CITY OF ALBUQUERQUE PLANNING DEPARTMENT July 23, 2014 DRB Comments

PROJECT # 1005081

APPLICATION # 14-70249

RE: Tracts A-1-A, B-1 & B-2, Andalucia at La Luz

**SKETCH PLAT**

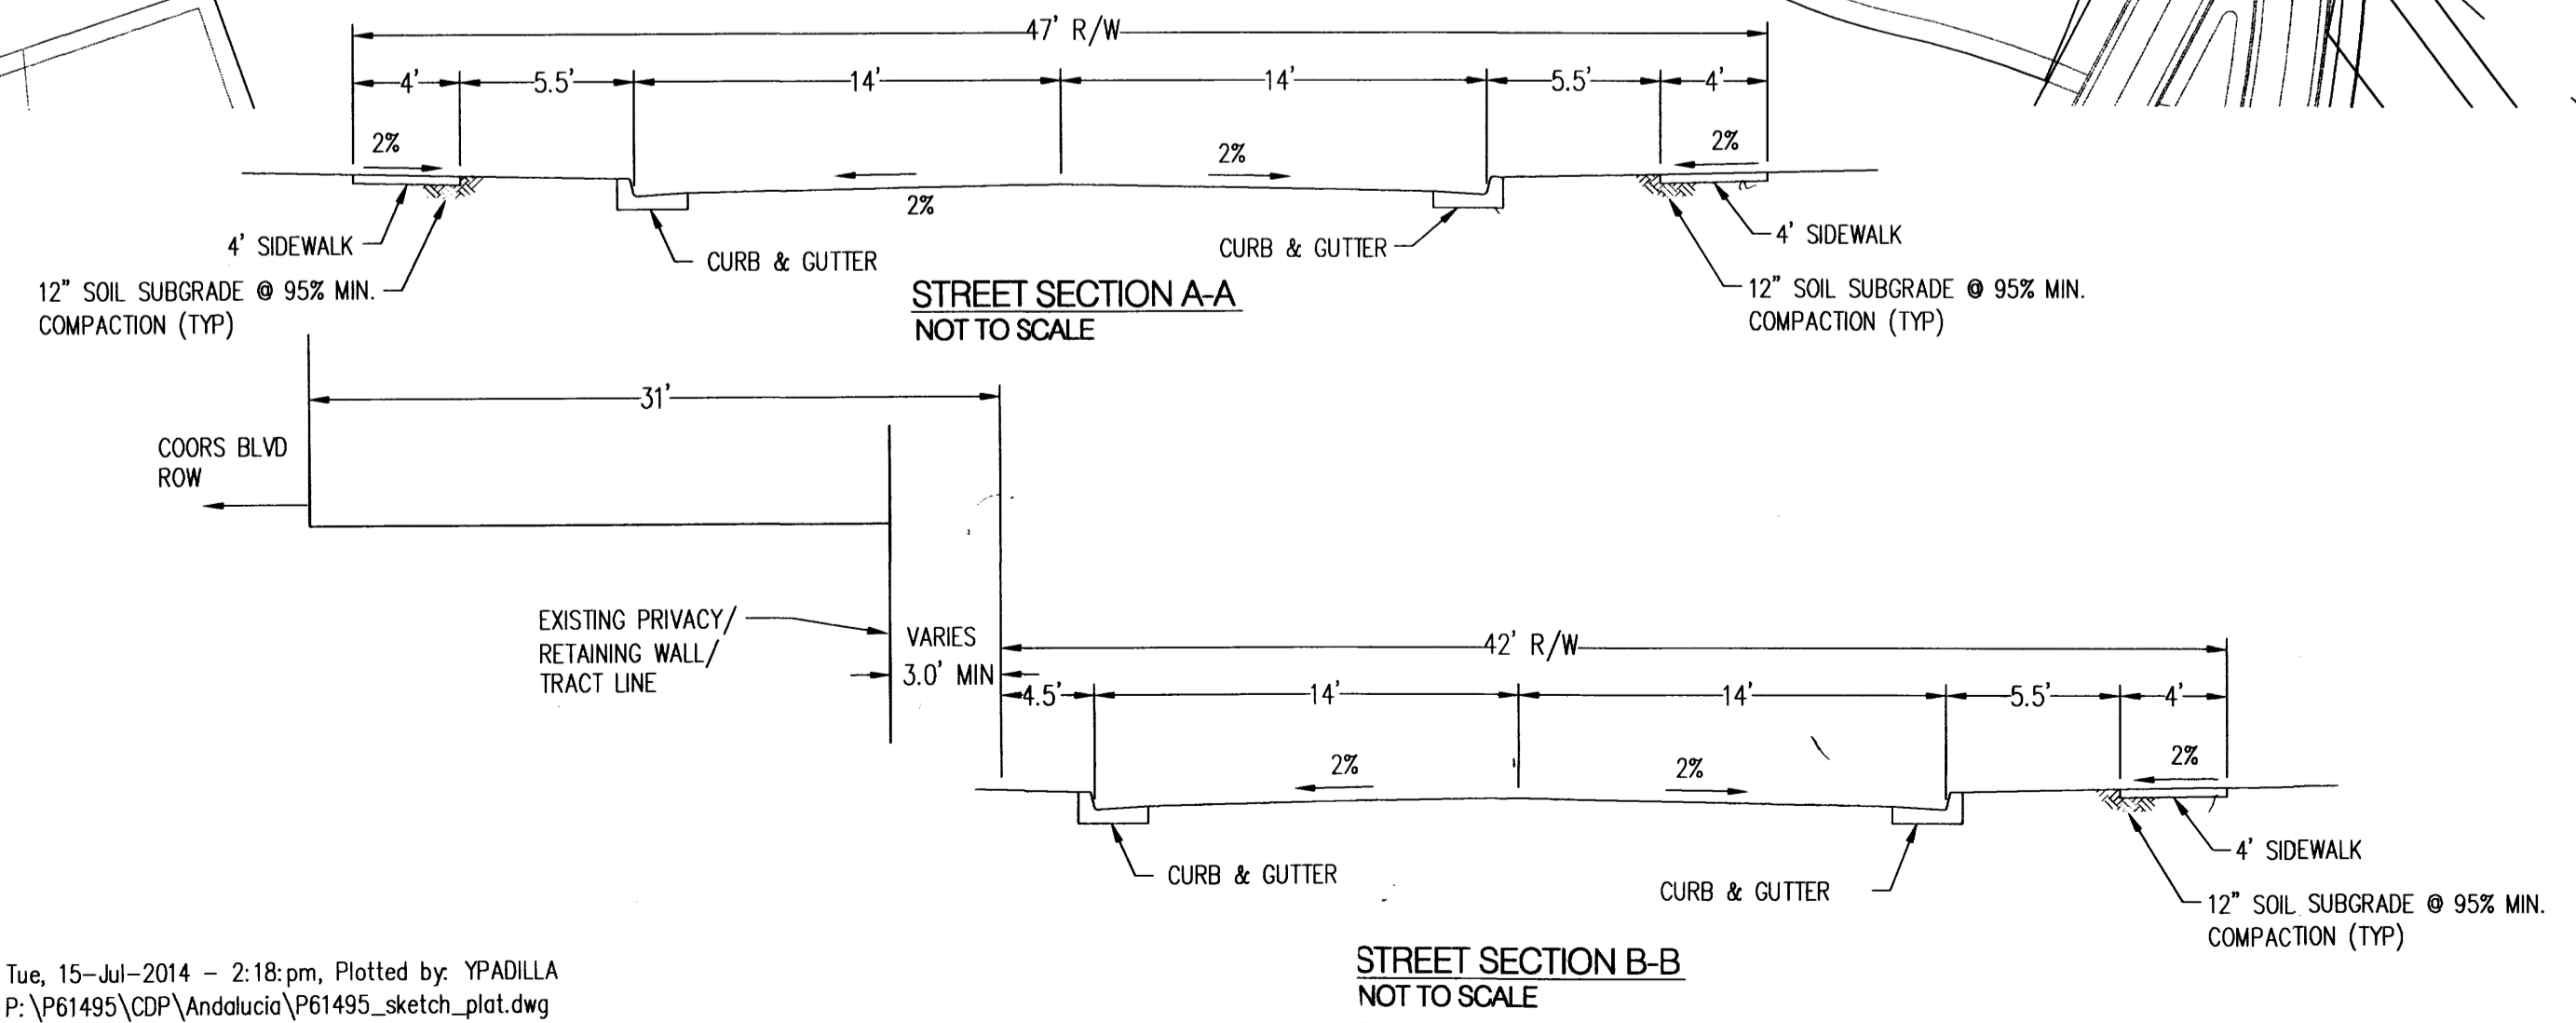
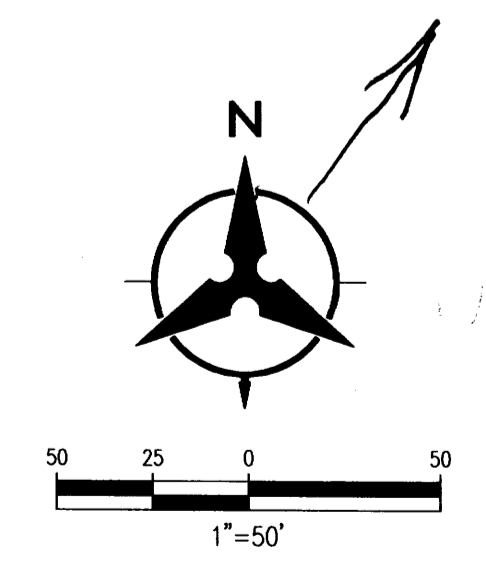
Please note to correct the Sketch Plat for Zoning and North Arrow orientation.

A Private Roadway Easement is needed for the turnaround of La Luz Loop One NW.

Two rows of double frontage lots are not suitable for subdivision; the proposed street adjacent to Coors needs to be eliminated (or find an alternative to eliminate the proposed street between proposed lots 32-36 and 37-39. Additionally the extension of the street adjacent to Coors to the NW corner of the site does not appear functional.
